REQUEST

Proposed Zoning: CG(CD) ANDO (General Commercial, conditional, Airport Noise Disclosure Overlay)

Approximately 1.519 acres located along the north side of Alleghany Street and the west side of Ashley Road, south of Lindbergh Street.

The petition proposes the development of a commercial use with an accessory drive-through on a vacant outparcel.

SHEET NUMBER:
C 1.0

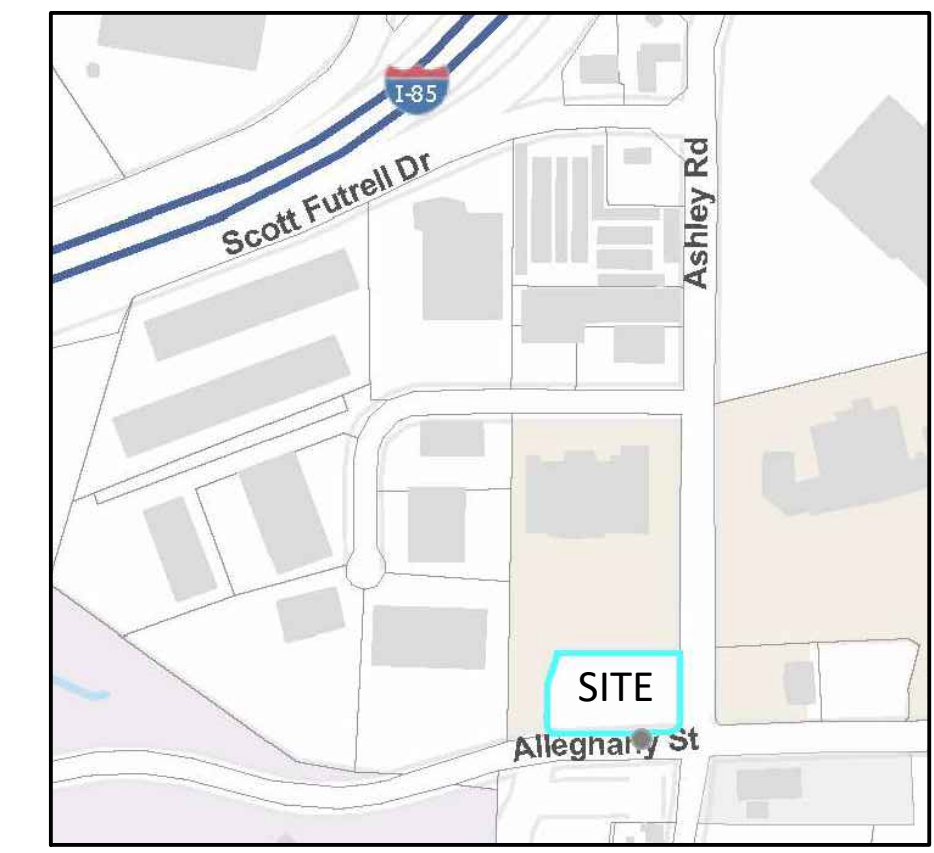
1. ~~Urban Forestry: Trees within the existing 30' setback along Alleghany and the 20' setback along Ashley Rd must be protected.~~ Addressed
2. ~~Urban Forestry: Sidewalk needs to be adjusted to protect existing trees within the ROW and setback.~~ Addressed

3. ~~Entitlement Services: Parking shown on site plan is in compliance with UDO requirements. However, parking calculations in Development Data Table are incorrect.~~ Addressed
